Our Ref: EN010091

Date: 26 June 2018

Application by Drax Power Ltd for an Order Granting Development Consent for the Drax Re-power Project

Advice following issue of decision to accept the application for examination

**TITLE:**  
Application Document Reference 2.5B  
Single Unit Option  
Indicative Plant Layout  
Key Plan - Sheet 1 of 9

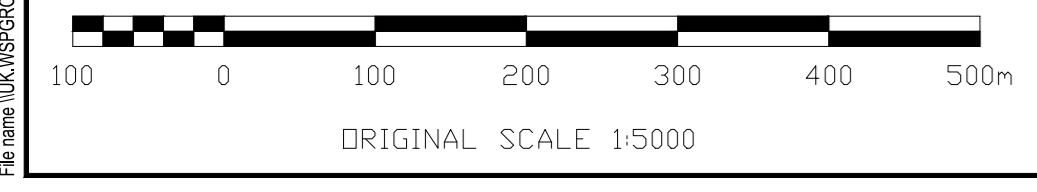
As noted in the checklist (Box 30, Regulation 5(2)(o)) the Indicative Above Ground Installation (AGI) elevations drawing depicts a building and a nearby satellite dish however these are not illustrated on either the Indicative Plant Layout plan for the 'one unit option' or the Indicative Plant Layout plan for the 'two unit option' for the AGI (Work 6 'above ground gas installation').

The Applicant is reminded to ensure that correct details are depicted on each plan and/or drawing and update the plans accordingly to avoid any confusion during the Examination.
